August 25, 2015

**RE: Western United Electric
Conceptual Grading and Drainage Plan
Engineer's Stamp Date 8-9-2015 (H10D029)**

Based upon the information provided in your submittal received 8-18-2015, the above referenced plan is approved for action by the DRB on the Site Plan for Building Permit. Prior to Building Permit the following comments must be addressed:

WESTERN UNITED ELECTRIC
CONCEPTUAL DRAINAGE PLAN

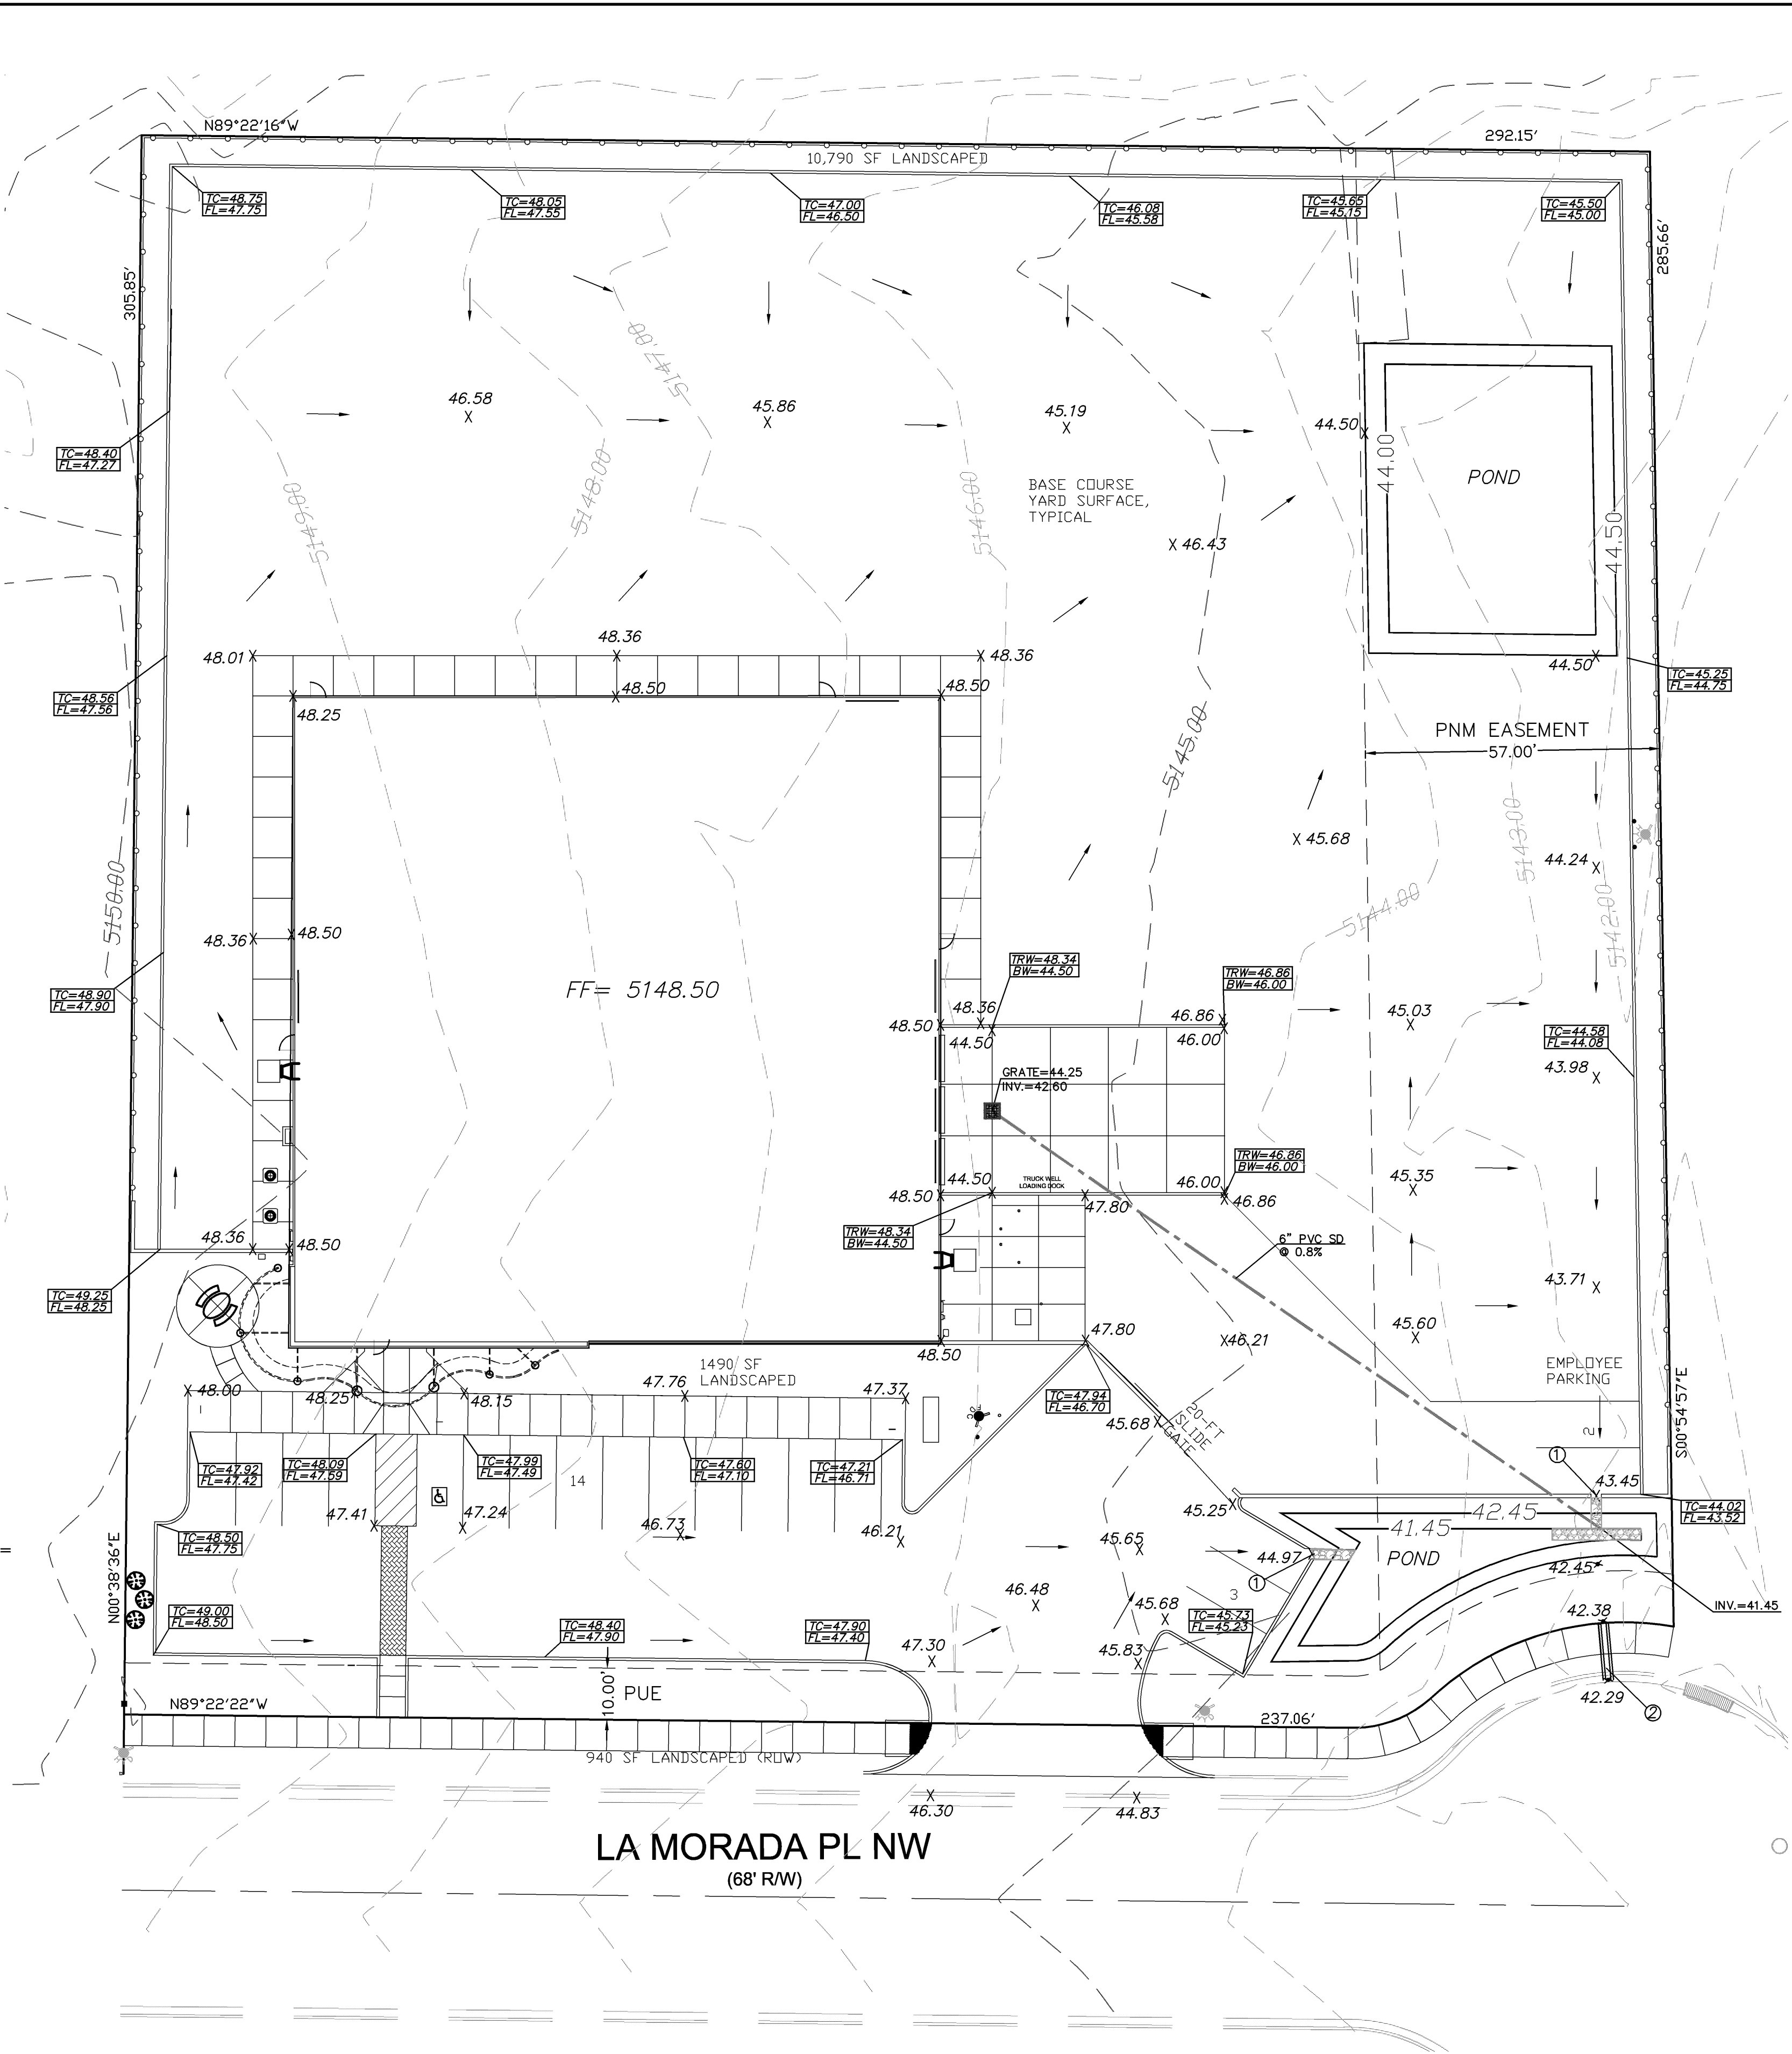
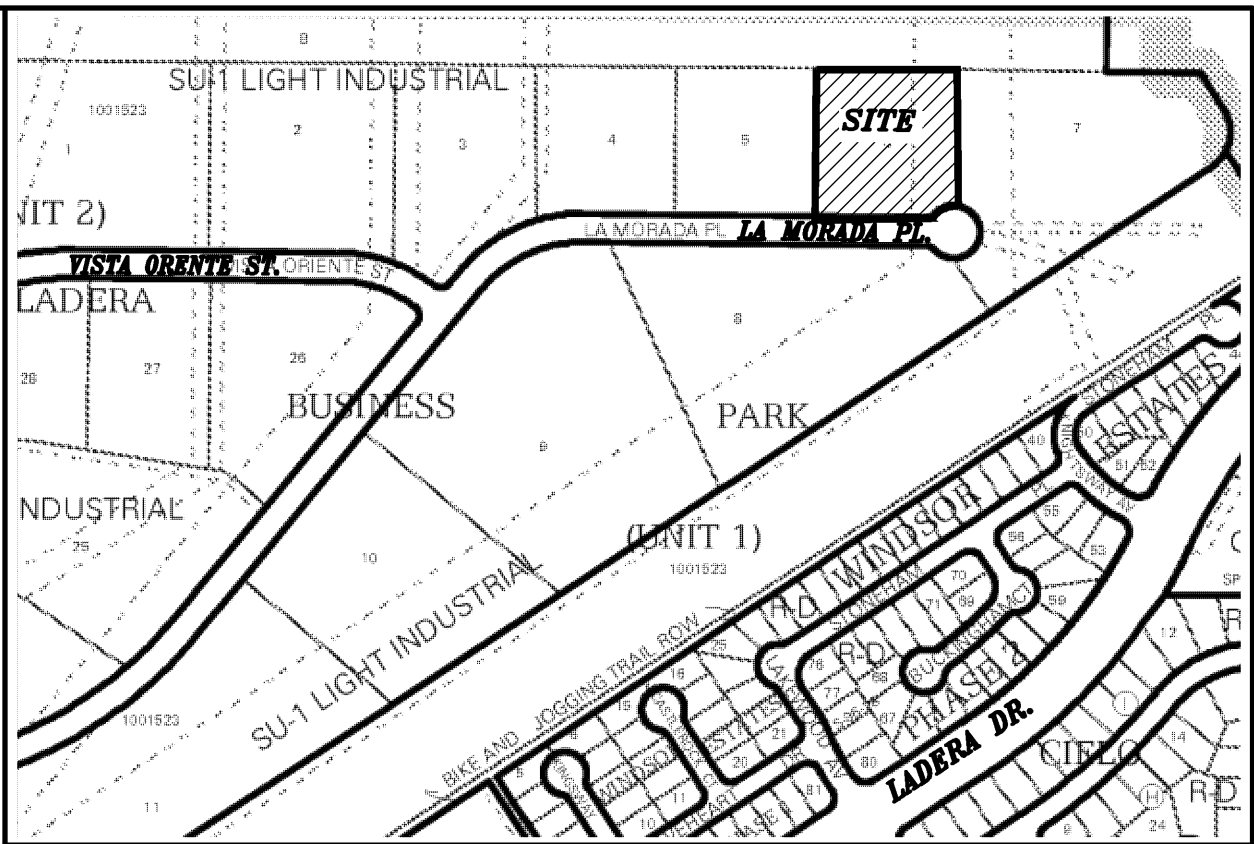
1. While the DMP states free discharge to La Morada is allowed for this site, the site is still limited to the discharge used in the original analysis. The AHYMO run shows 8.13 cfs. A copy of this information should be provided as part of the excepts, but I will include it in the file for you. It is based on a D=80%

2. DMP shows that offsite basin 6-A was intended to flow thru this site to La Morada. Please address.
3. In the runoff calculations shown on plan, do not include the AHYMO input/output for the 10yr storm as it is not needed and confusing.

4. Site plan shows that crushed gravel is used in the north portion of the lot and should be noted on the grading plan. Is the intent to pave in the future? The AHYMO input shows D= 88%. Should it be lowered?

5. How are flows from Pond A getting to Pond B? Show a channel or swale and a section cut.
6. SW culverts are sized using the orifice equation but they are above the pond. Use the weir equation.

7. Show how flows are conveyed from Pond B to the SW culvert. Provide additional spot elevations around Pond B.
8. Provide SO-19 notes if this is not going thru the Work Order process.

9. The 1ft retaining curb does not appear to be sufficient. Show slope ties.
